## City of Albuquerque Stormwater Construction Site Inspection Report

General Information					
ESC File No.	A11E017C	Project Name:	Tidal Wave Care Wash		
NPDES Id. No.		Location:	10601 Unser Blvd		
3/13/2023	Owner			Contractor	
Operator	TWAS Properties LLC				
Contact name & title	CO Joshua Skarsgard				
e-mail	Josh@retailsouthwest.com				
Contact Phone #	262-2323				
COA Inspector	Doug Hughes		Start/End Time:	9AM	
Construction Phase:	Building on lot 4 & both new and old disturbance on other lots				
Type of Inspection:	Regular	Storm Event	Post Storm Event >0.25"	311/Complaint	Follow Up
Weather at time of inspection?	Clear		Temperature: ~	50	
Estimated date of last storm 0.25" or greater	12/4/2022

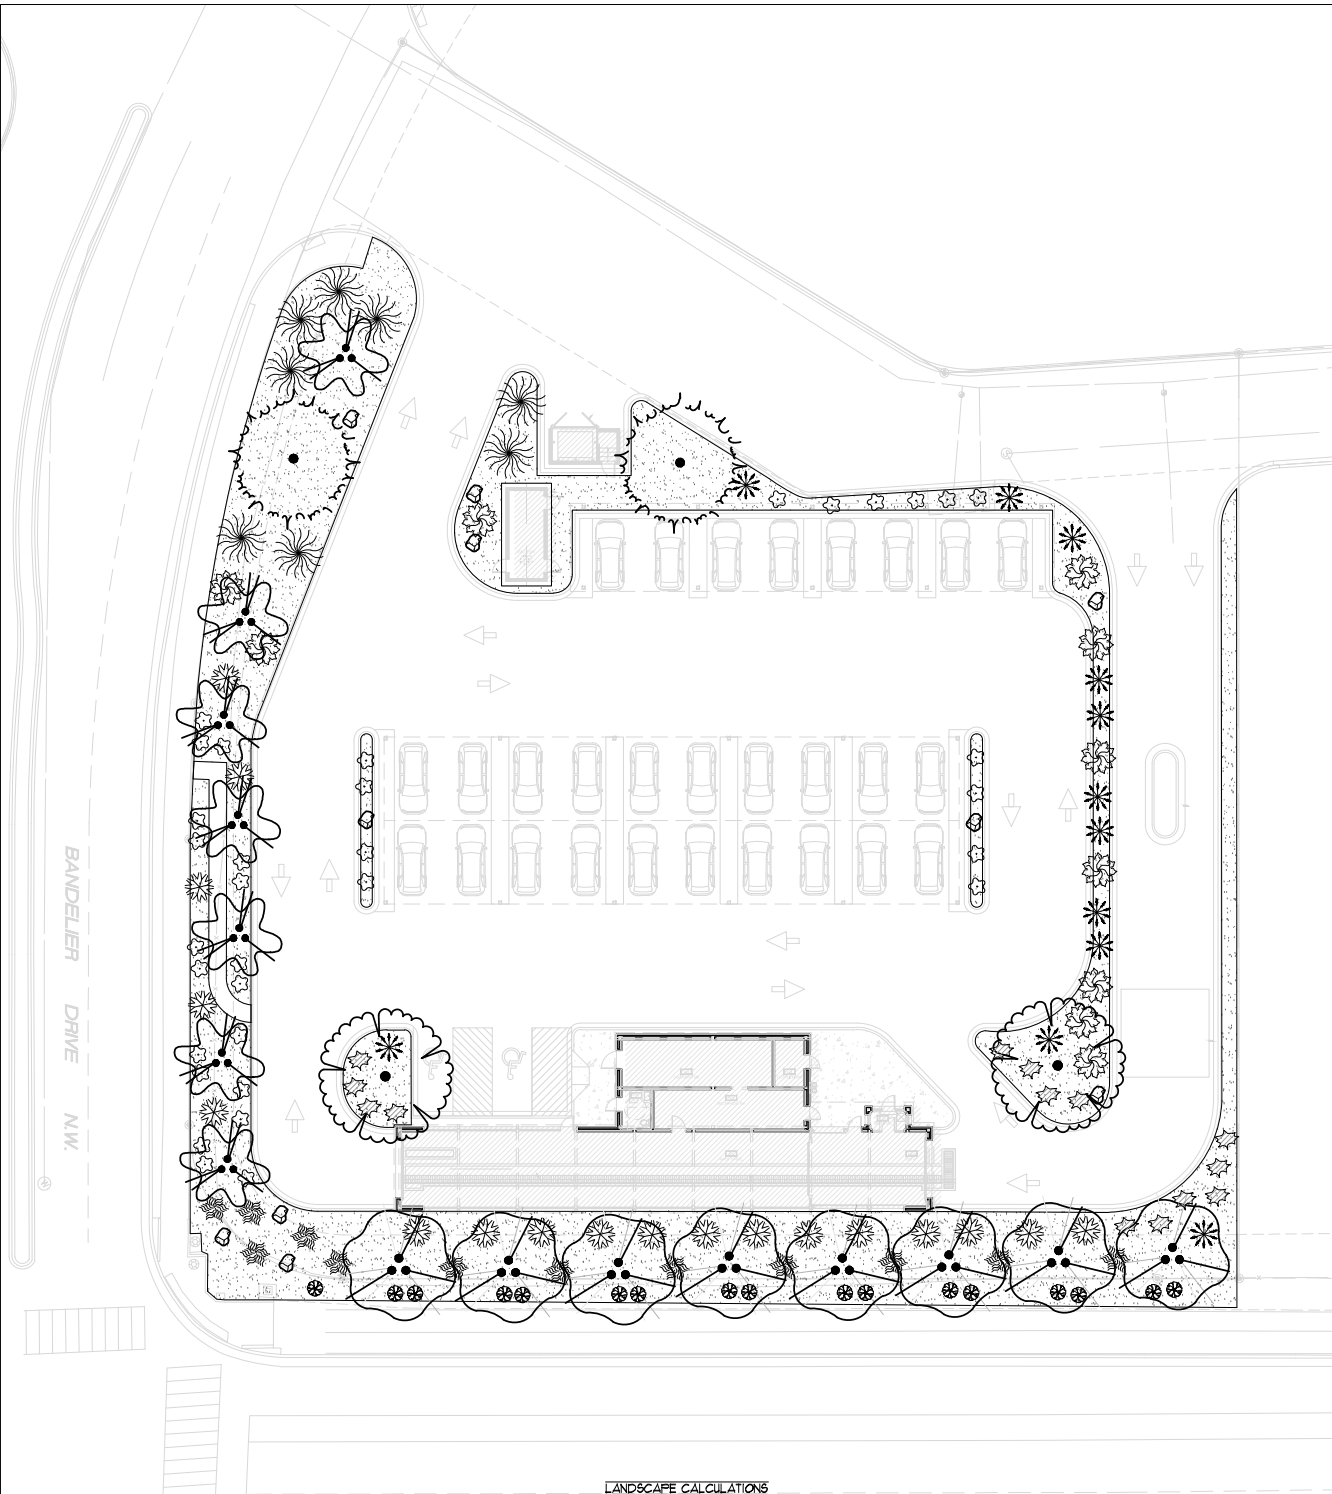
4	Stabilization was missing - You must continue permit coverage, self-inspections, SWPPP and BMP maintenance until the City determines that the Final Stabilization Criteria CGP2.2.14.c has been satisfied. Then you must remove the BMPs and send documentation of the Final Stabilization to the EPA with a Notice of Termination (NOT) per CGP 8.2 to end your coverage under the CGP. This step is independent of the Work Order. Please copy me with the documentation and the EPA's acceptance of the NOT at that time. In the meantime seed and Hydromulch are required per CGP 2.2.14.				
5	BMPs missing - Silt fence is full of sediment on the east side. It is missing on the west side. Silt fence is required around the perimeter until the final stabilization criteria is satisfied.				
6					
7
